Ask for:	Erika Davies
Telephone:	01832 742207
Planning Services	Planning.enc@northnorthants.gov.uk
Our Ref:	NE/21/01069/FUL
Your Ref:	PP-09997866
Date:	13 July 2021

Proposal : **Single storey ancillary accomodation to replace existing single garage. at Pond Yard 32 Back Lane Collyweston Northamptonshire PE9 3PJ .**

**PROPOSED**  
Location & Block Plan

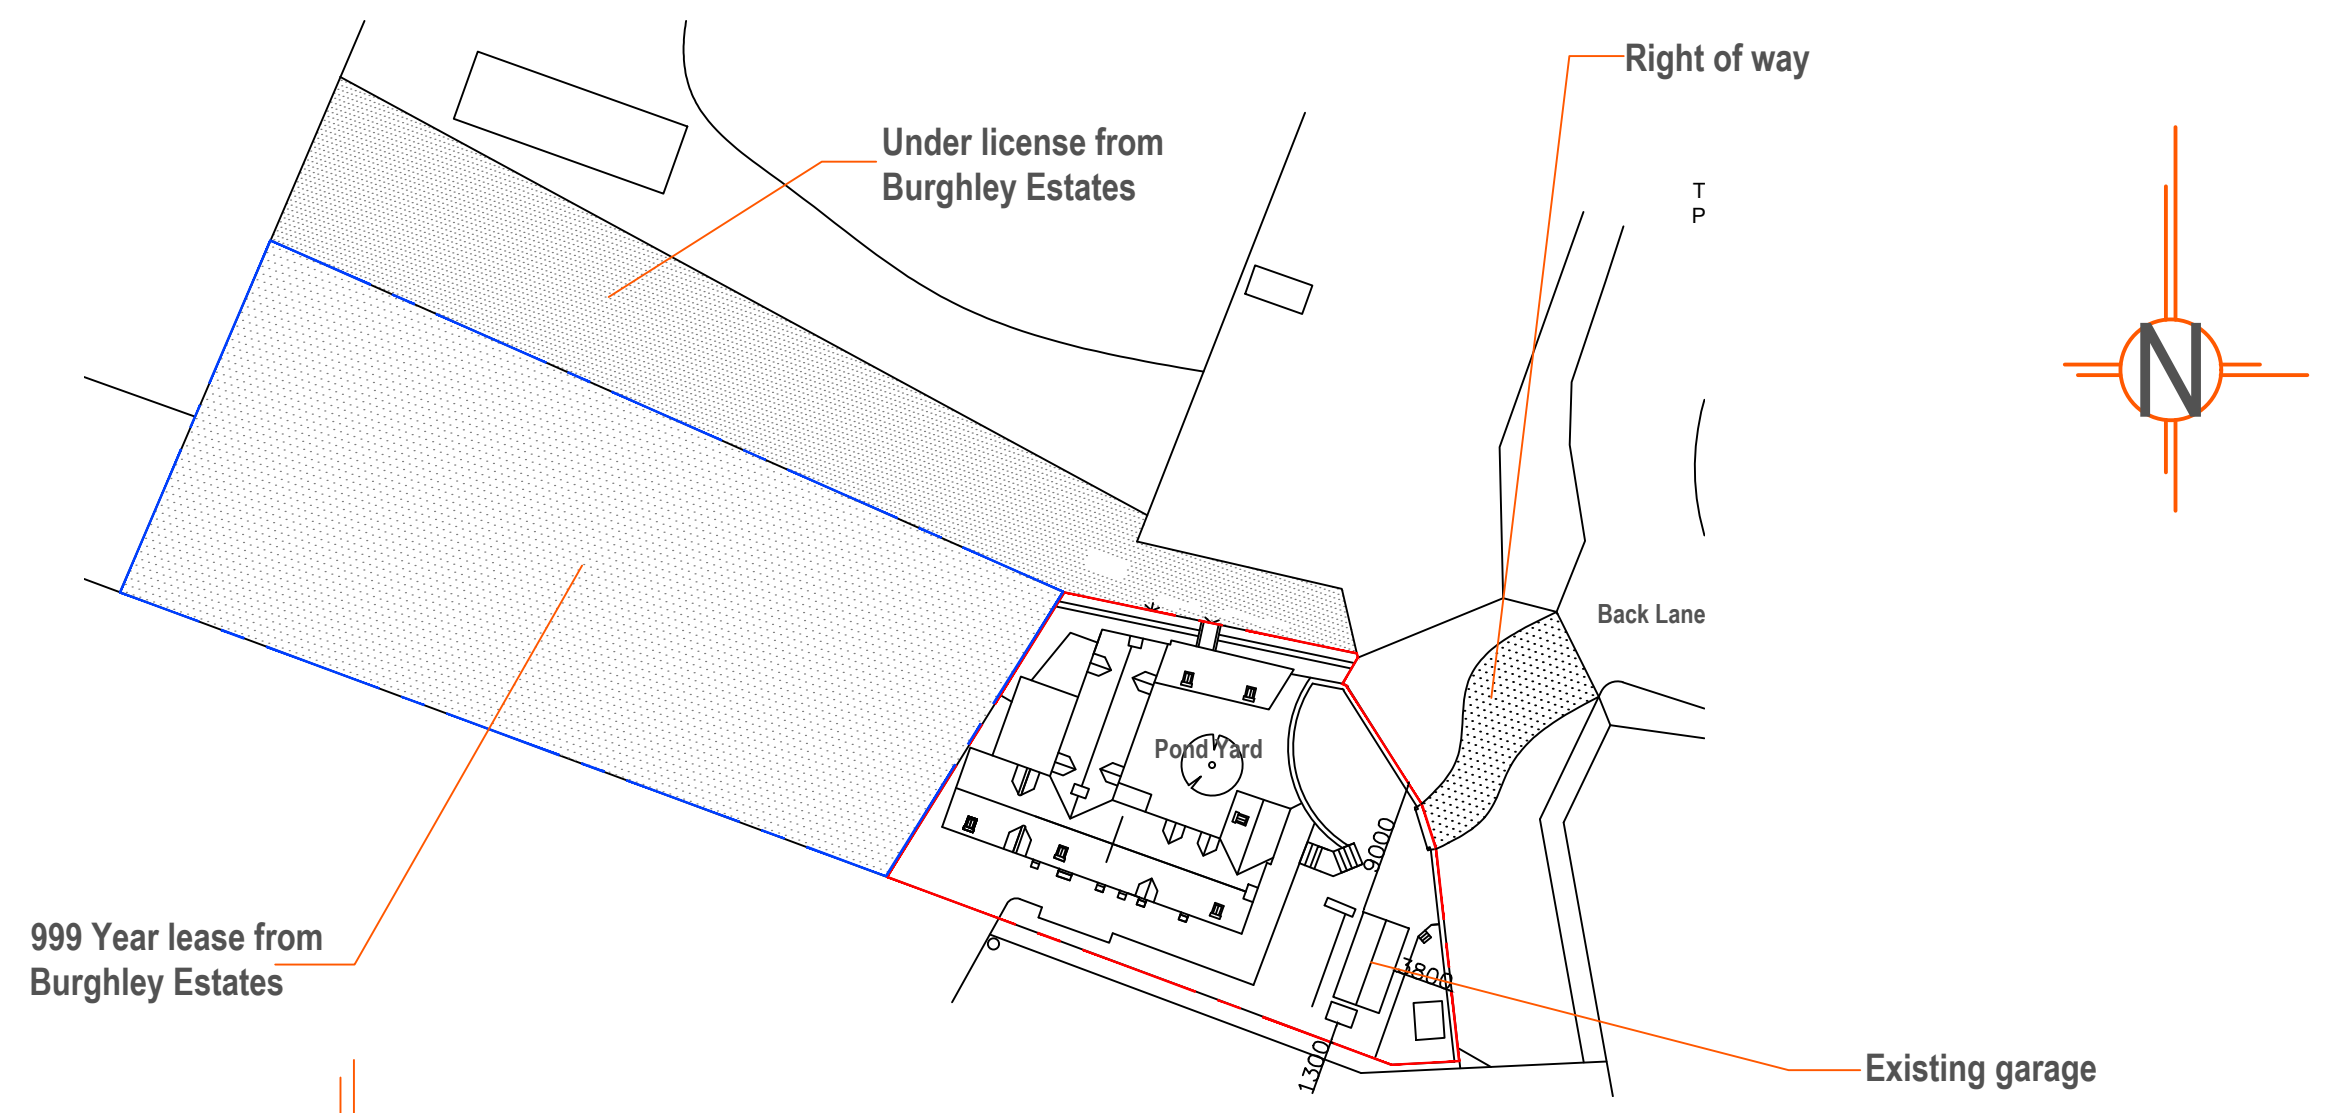
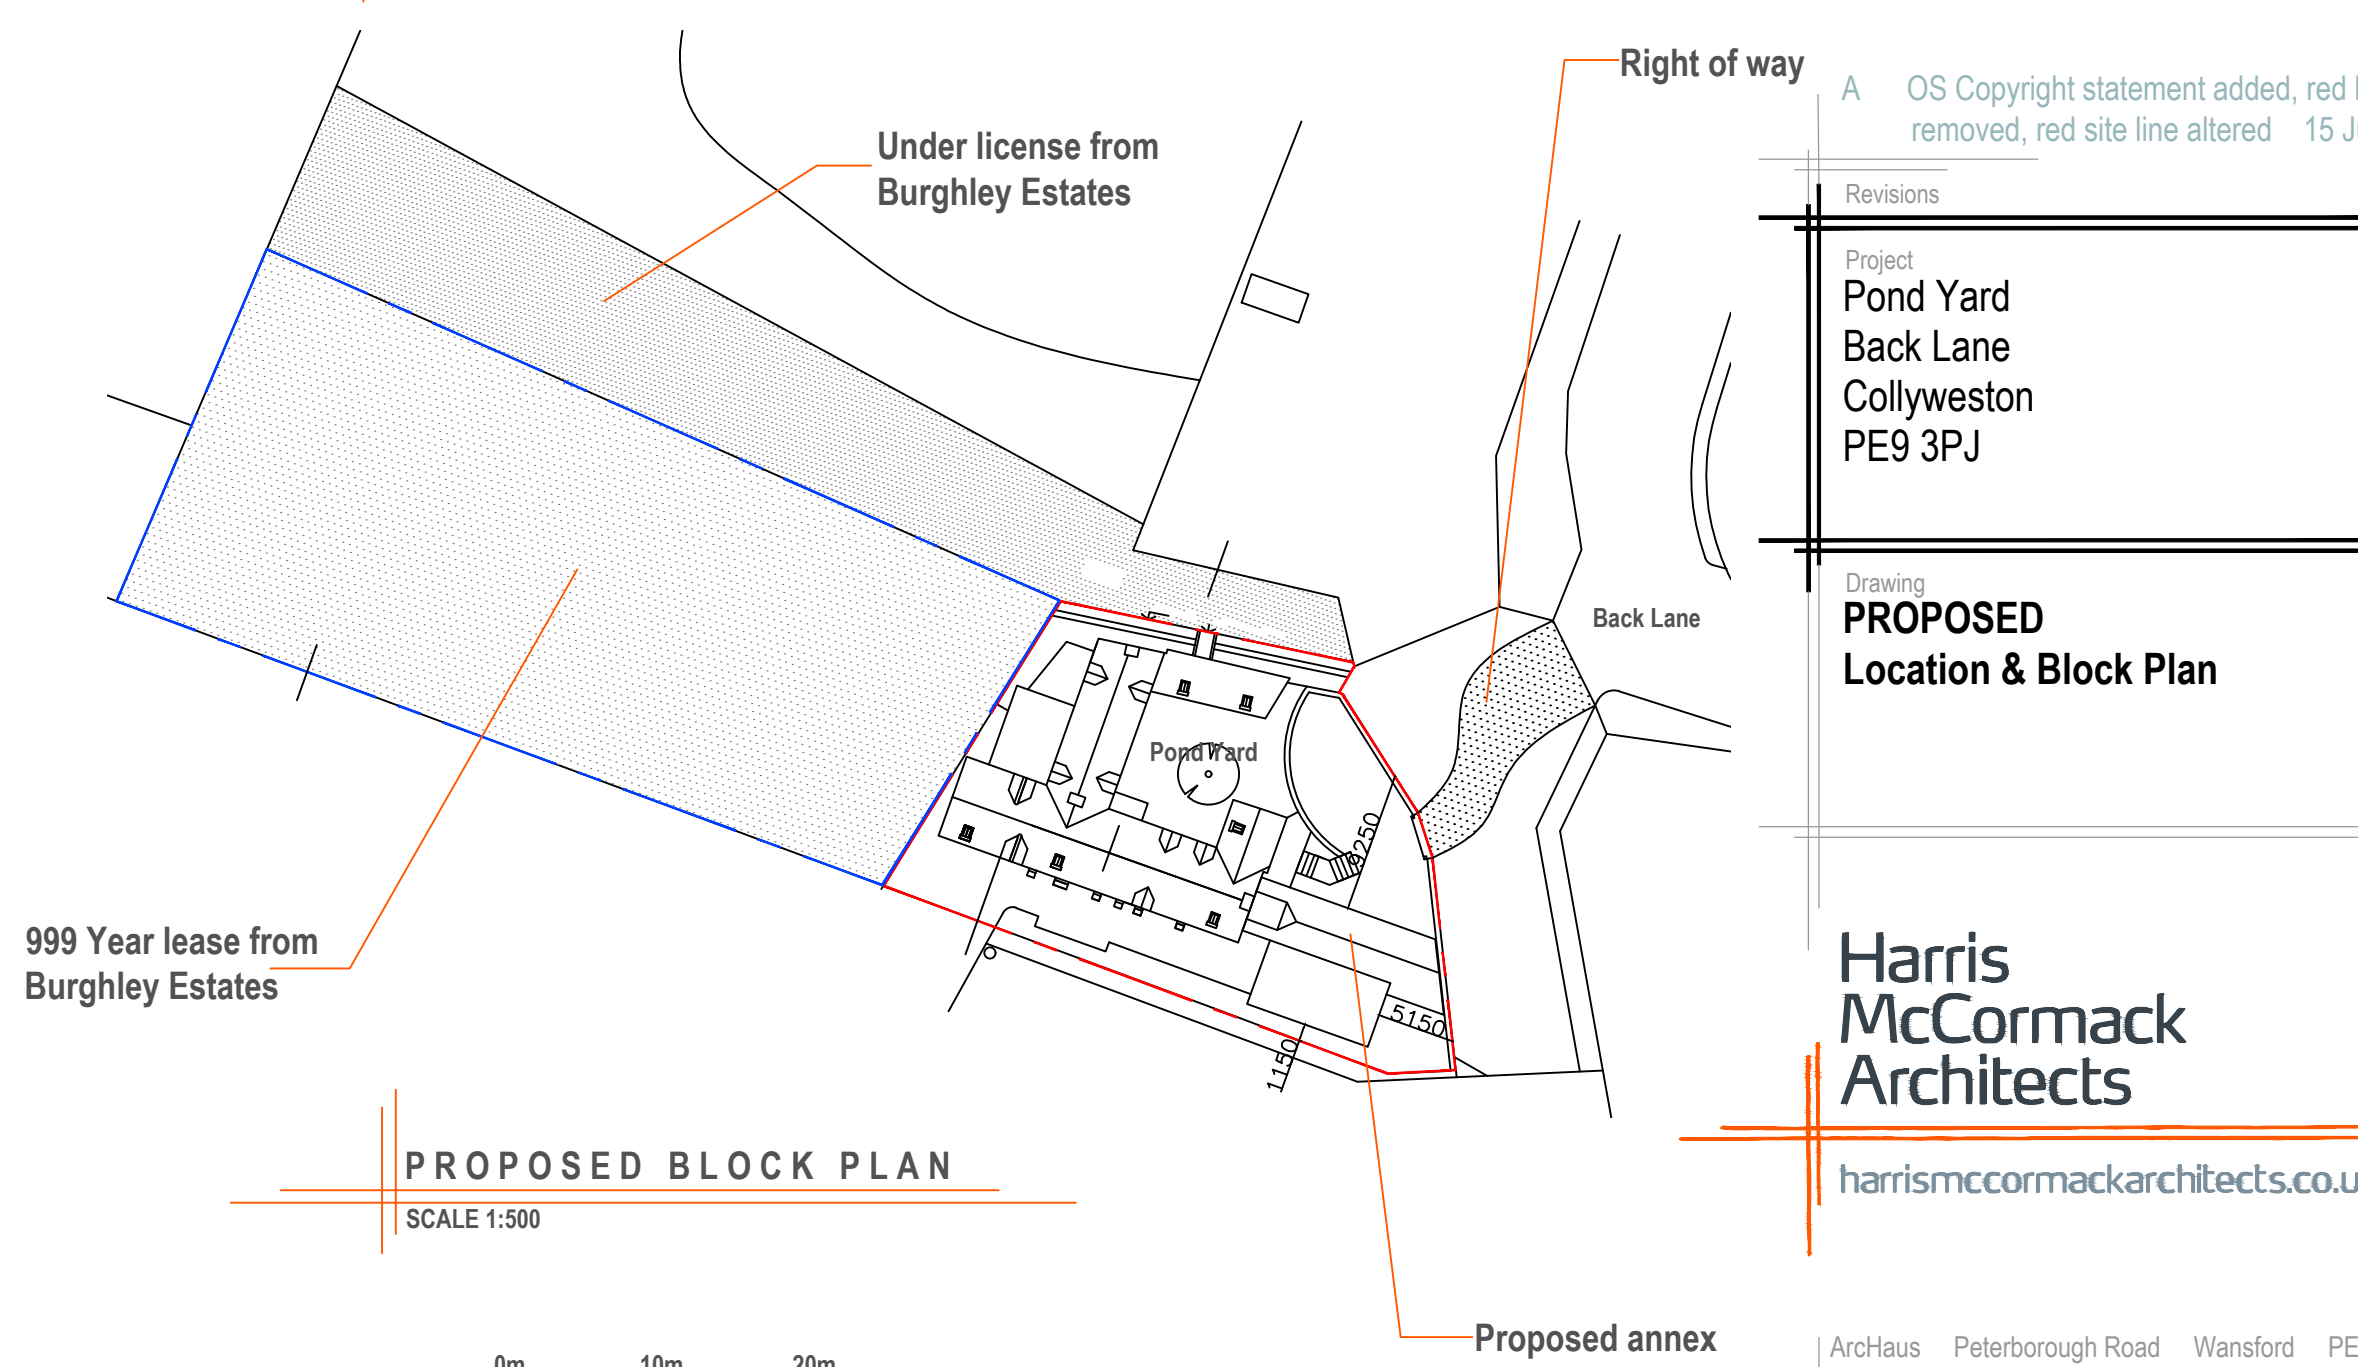
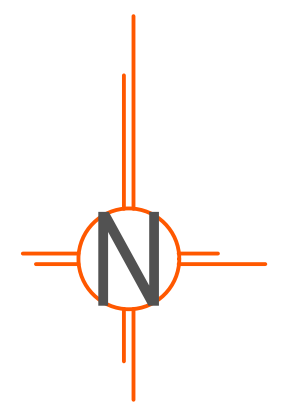
1. Please provide a location plan, to a scale of not less than 1:1250, showing the location of the site edged in red, this line must include all land necessary to carry out the proposed development (including the land required for access to the site from a public highway, visibility splays, landscaping, car parking and open areas around buildings), any adjoining land in which the applicant has an interest should be edged in blue, the plan must include a "North point", if an Ordnance map is issued please ensure a copyright statement is included e.g. 'Contains Ordnance Survey data © Crown copyright [and database right] 2015'. This is required as the Ordnance Survey is tightening up on infringement on their copyright.

2. Please provide a site plan to a scale of 1:200 or 1:500, including a "North" point and showing your proposals for the new works in relation to the site boundaries and other buildings within and surrounding the site, on-site access and parking.
